From: [REDACTED]
To: [Hinckley SRFI](#)
Subject: Hinckley National Rail Freight Interchange Response by IP 20038907
Date: 06 February 2025 17:11:36

Interested Party Reference – 20038907

Comments on the TSH response (10 December 2024) to the SoS letter (10 September 2024)

Proposed Layout - 16.5m Max Legal Articulated Vehicle

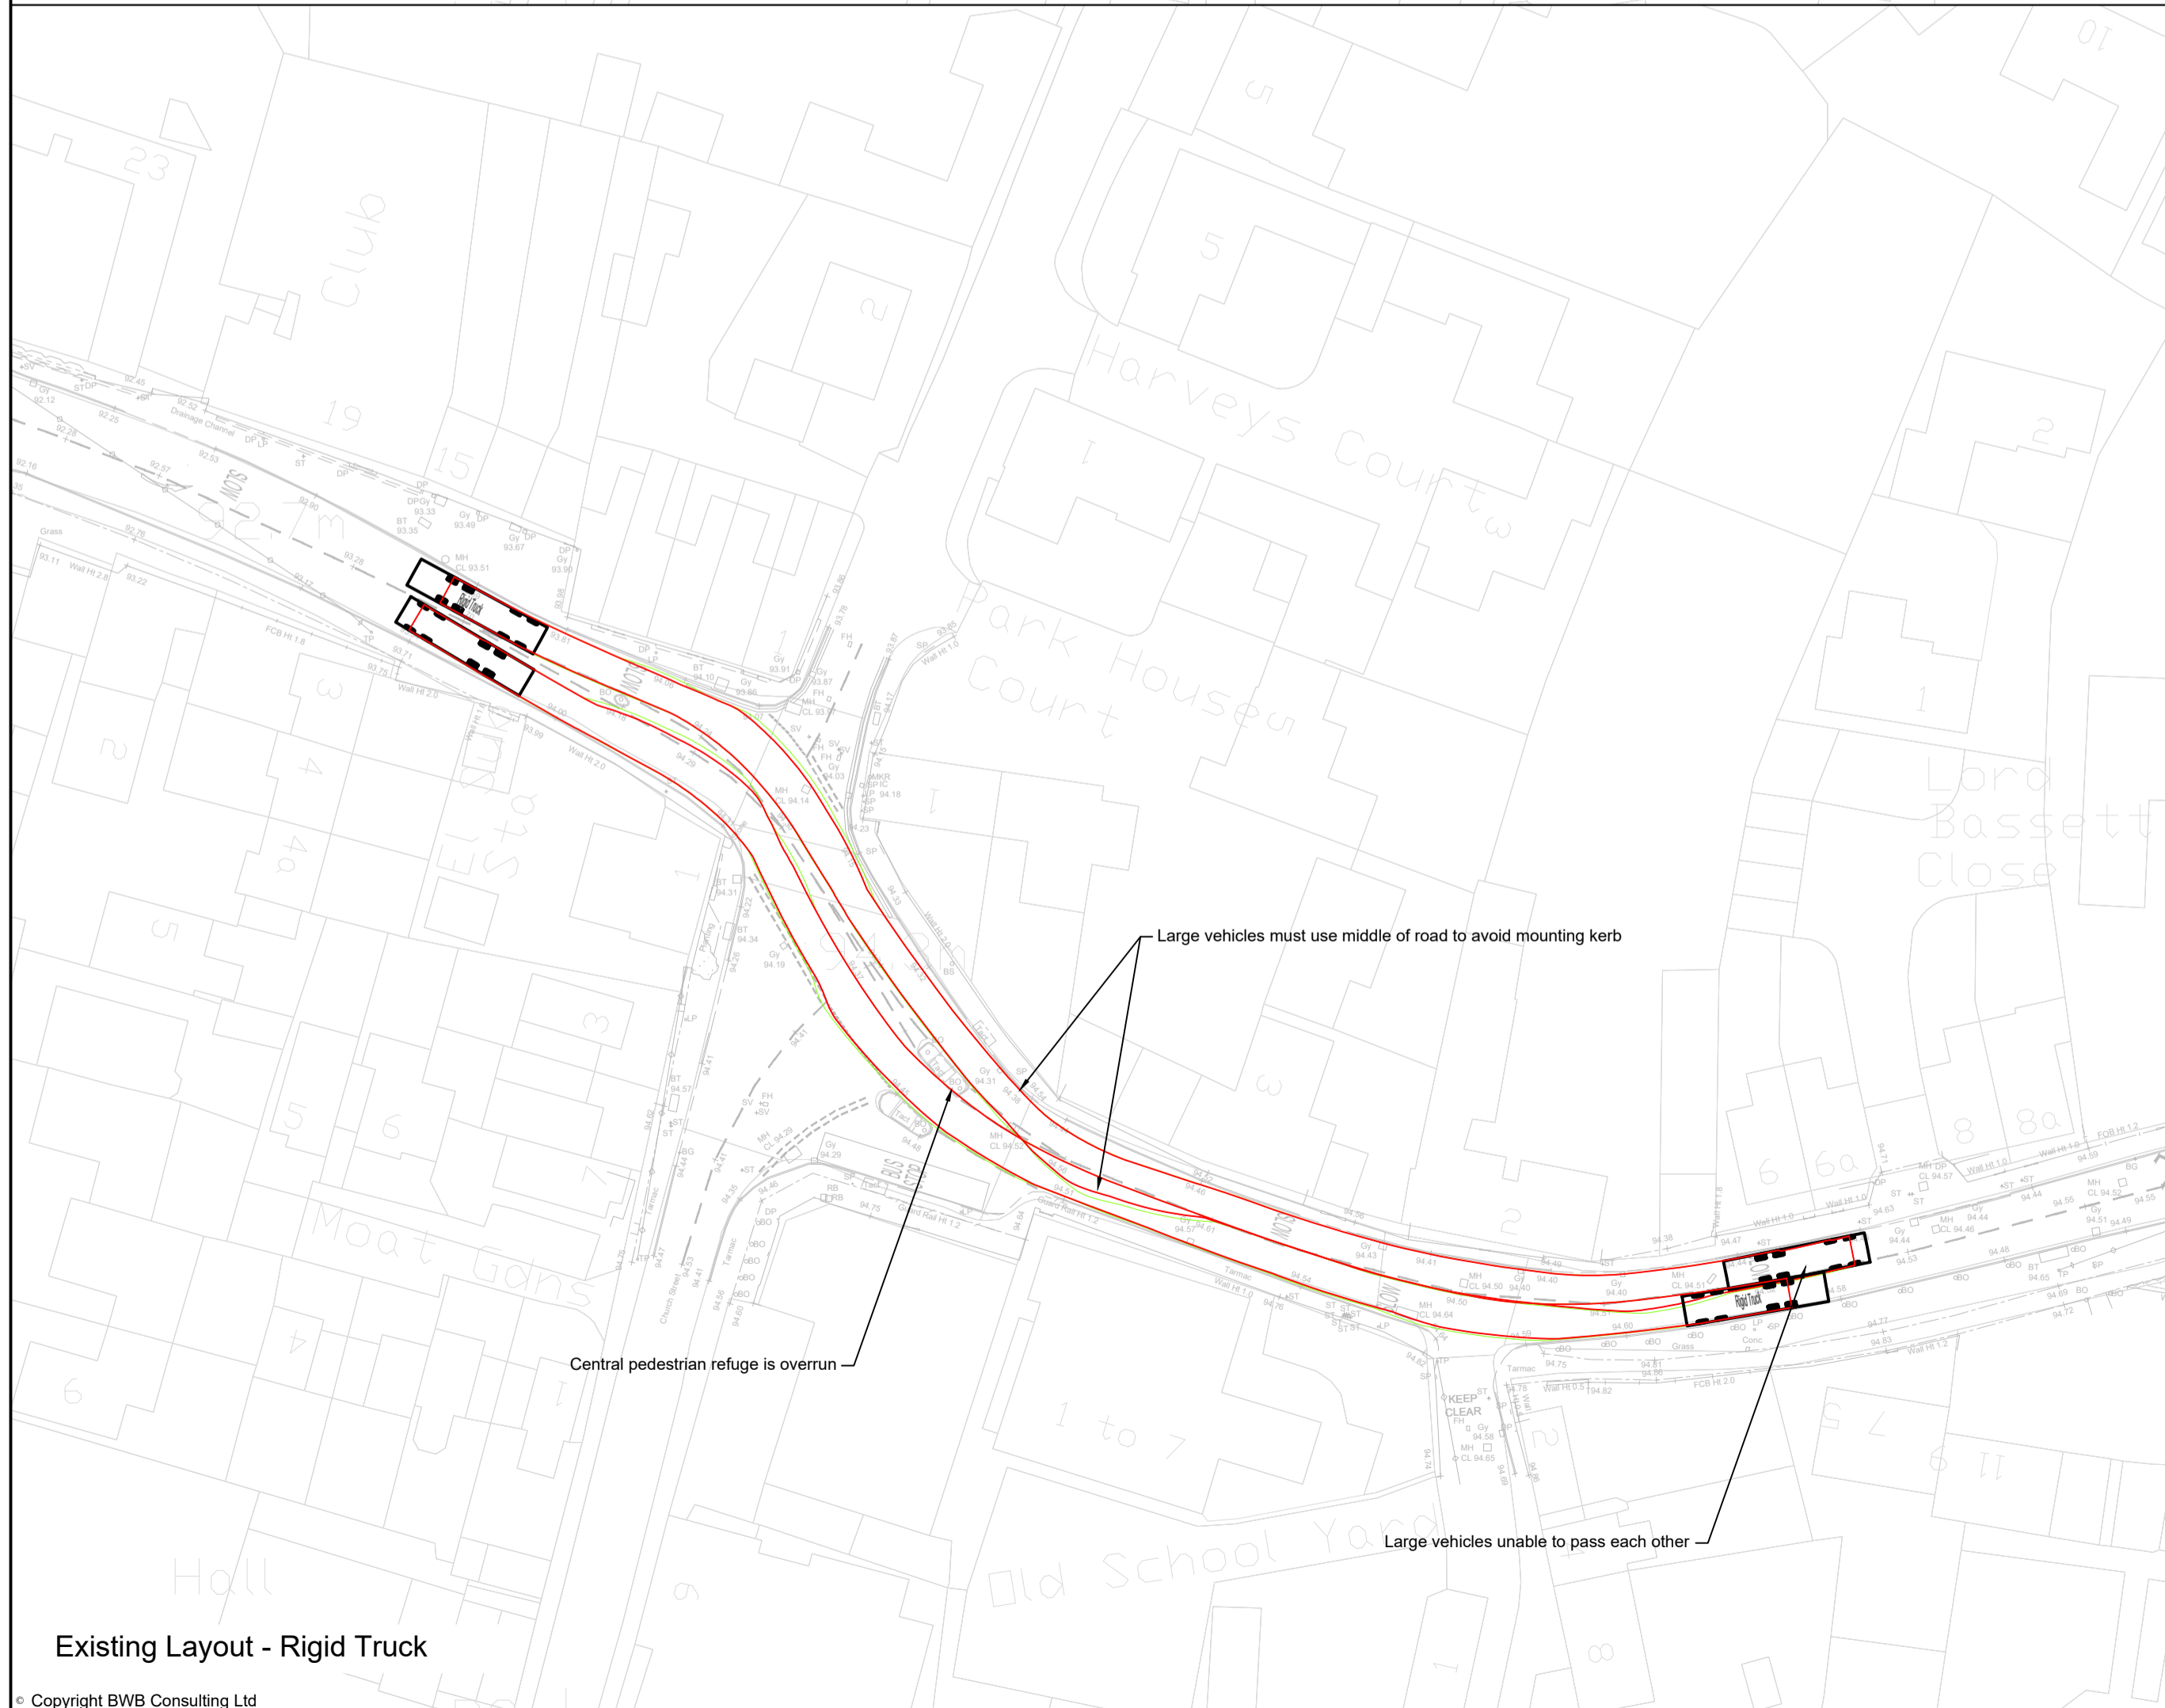
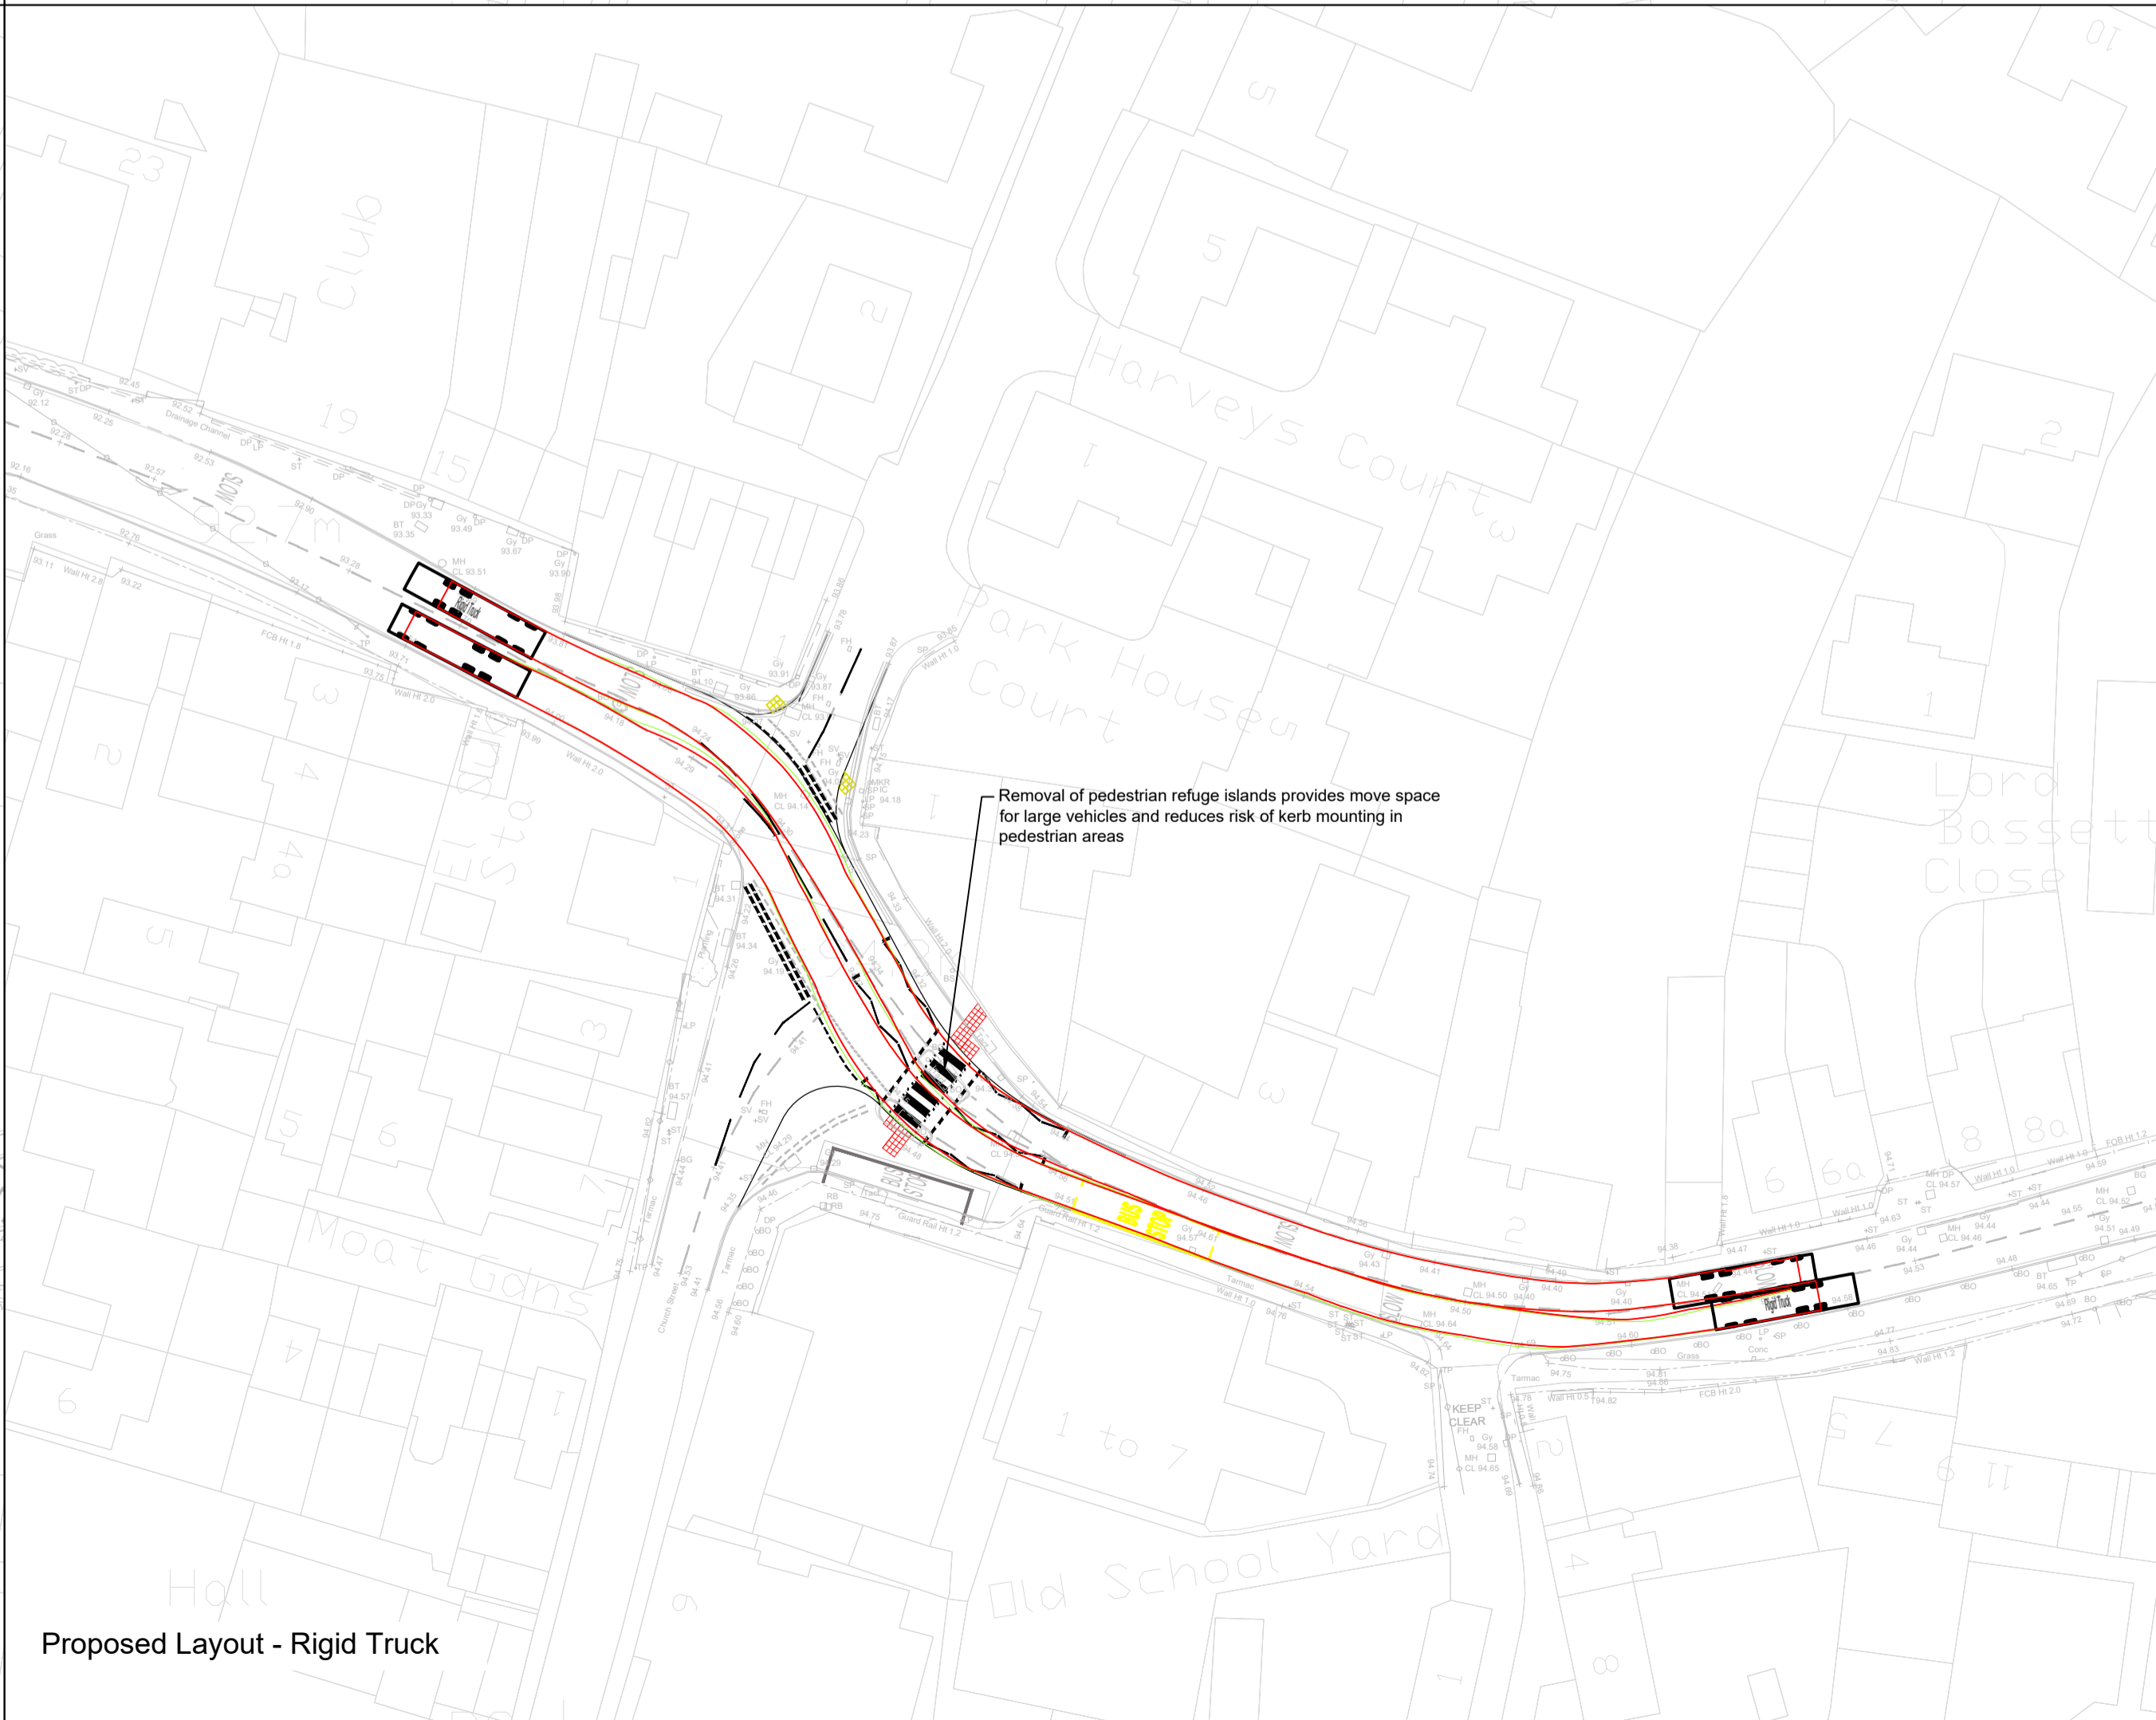
notion of reducing the width of the road to ensure that only one HGV could get through would inevitably cause more safety problems to a situation that is already an issue. It is a poorly thought out 'solution' as there is no provision for what happens when there are two oncoming vehicles in the narrow part of the road, forcing a vehicle onto the pavement to avoid collision. There is no provision for who would be required to give way.

Proposed Layout - School buses waiting in loading bay in front of Co-Op

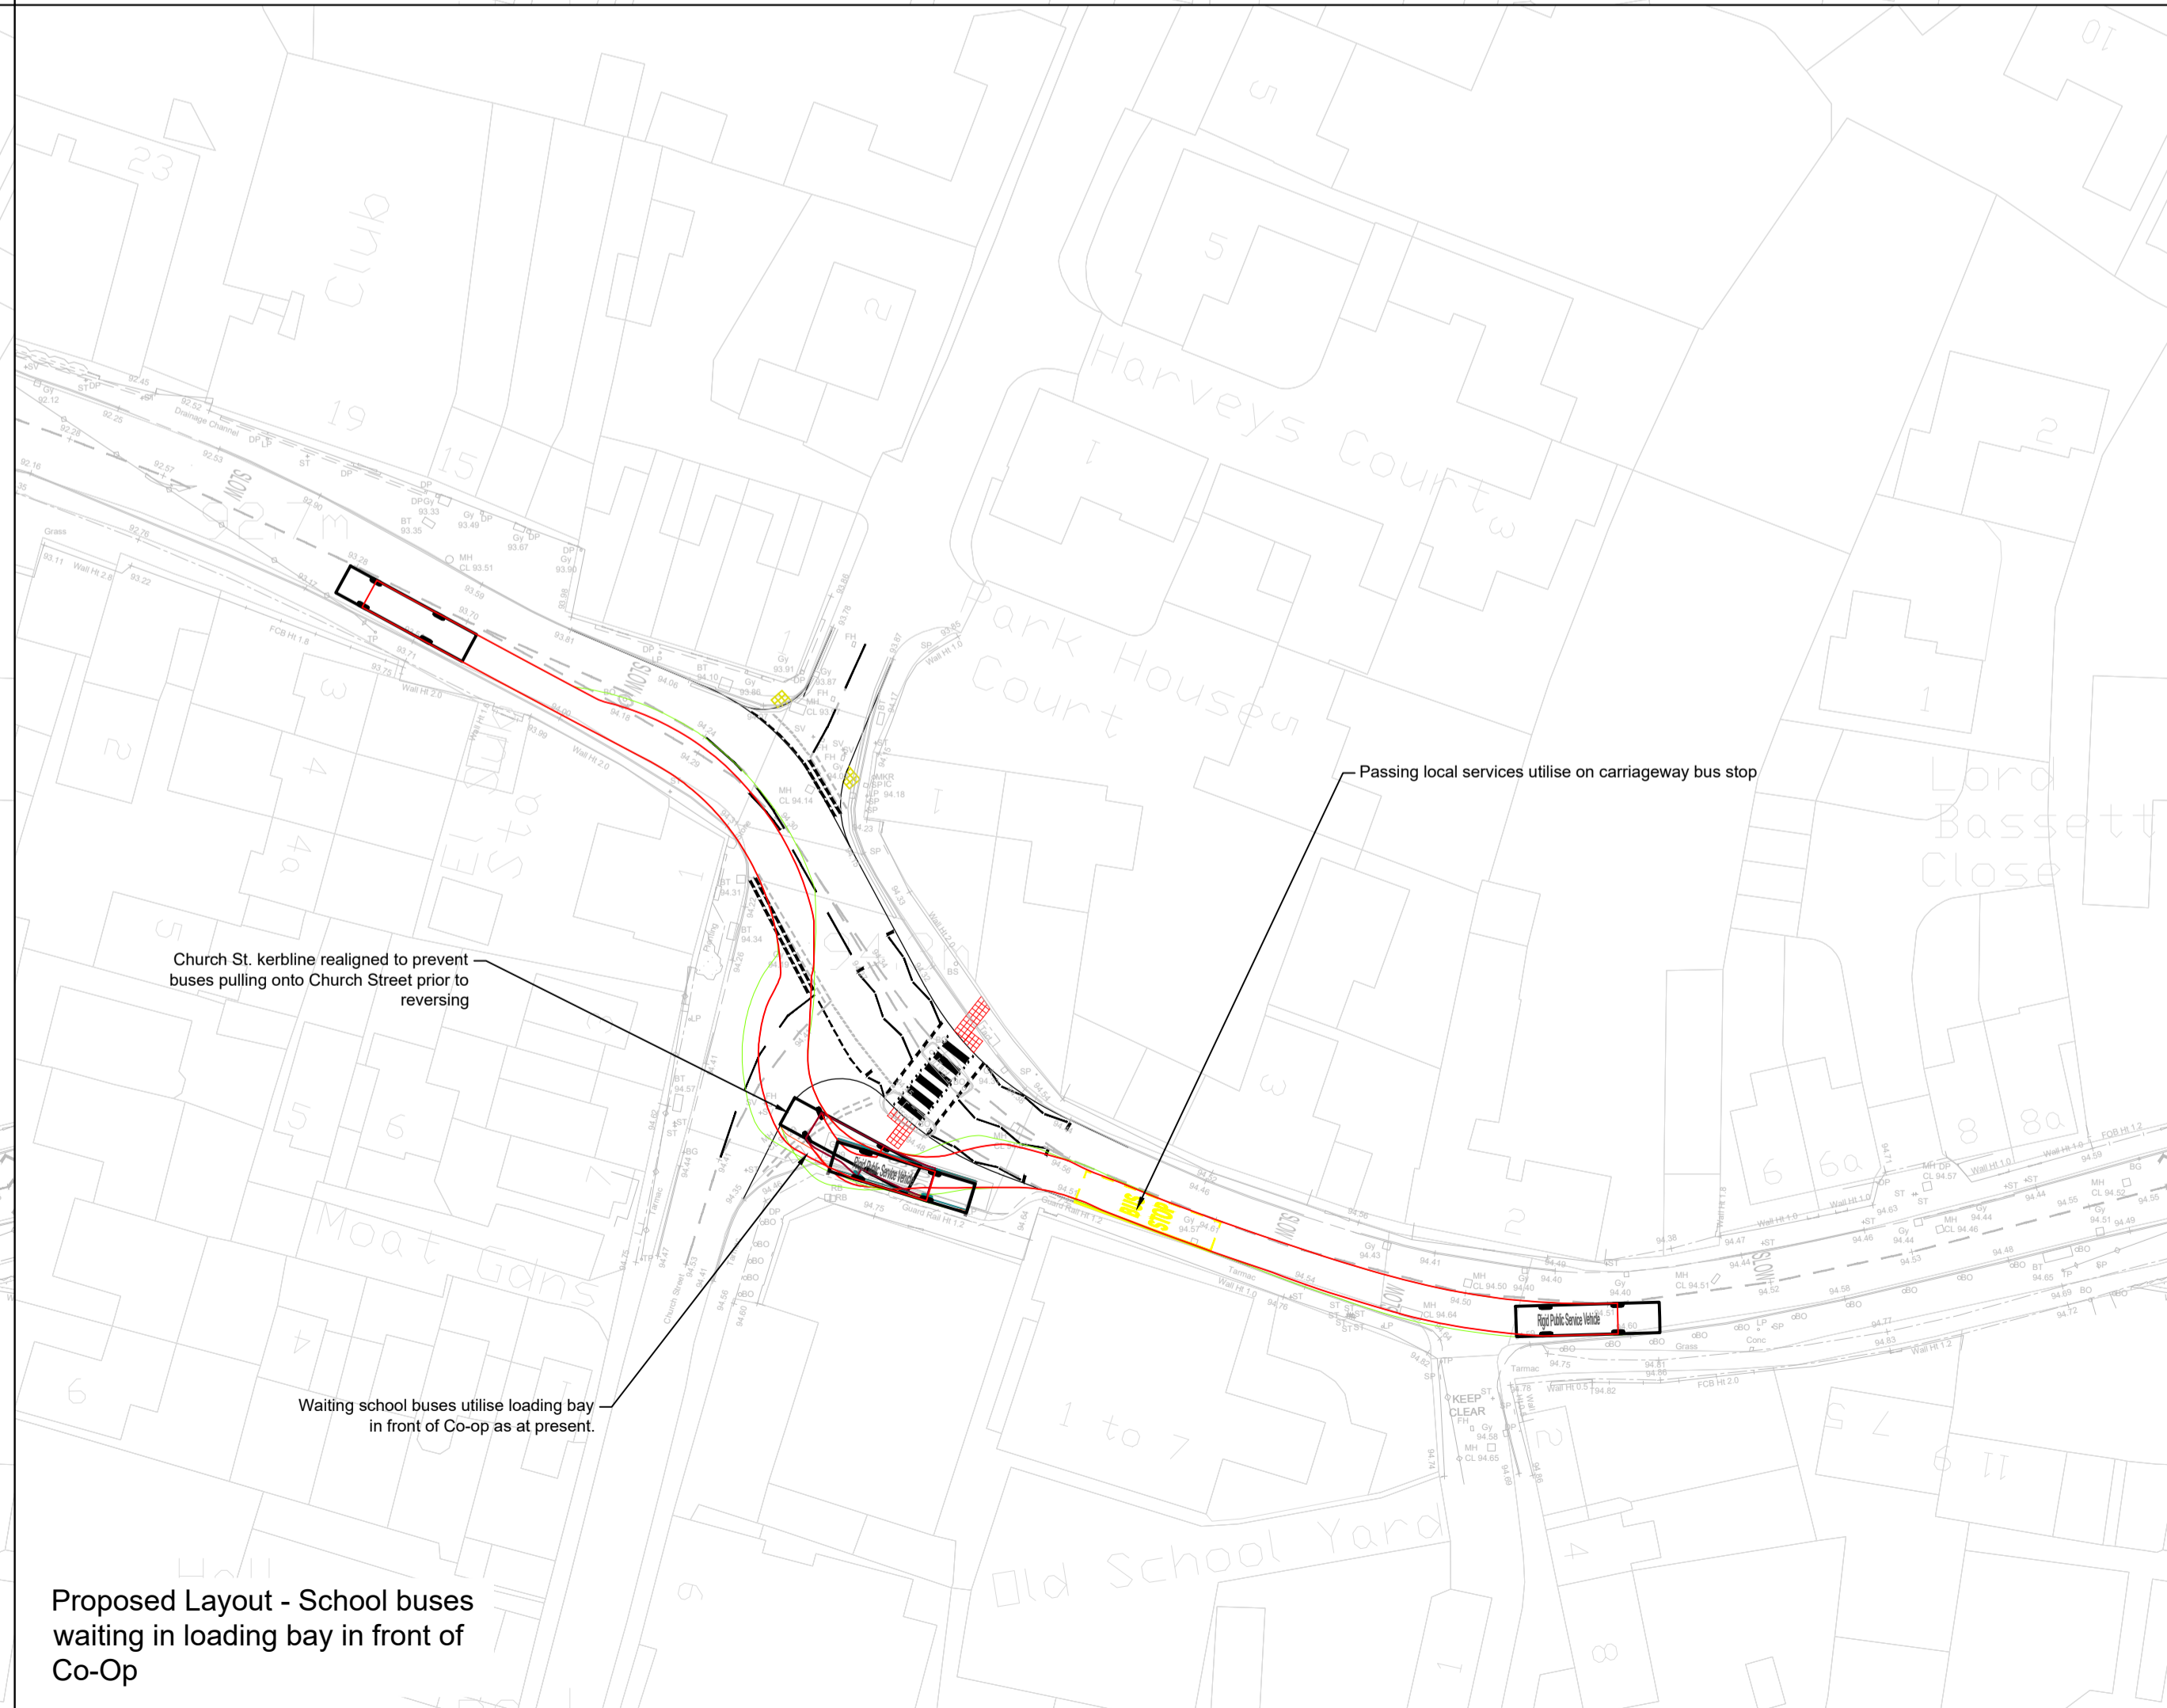
The proposal to move the bus-stop into a lay-by raises several concerns and no apparent contingencies. For example, if a bus is in the lay-by, it obscures the on-coming traffic warning sign to other vehicles. It is a busy area, with children waiting for school buses, deliveries to the Co-op, residents accessing the shop, parents taking children to and from school, delivery and collection of goods from the parcel drop facility. In proximity there is a day-nursery, a residential home, other businesses, as well as residential properties.
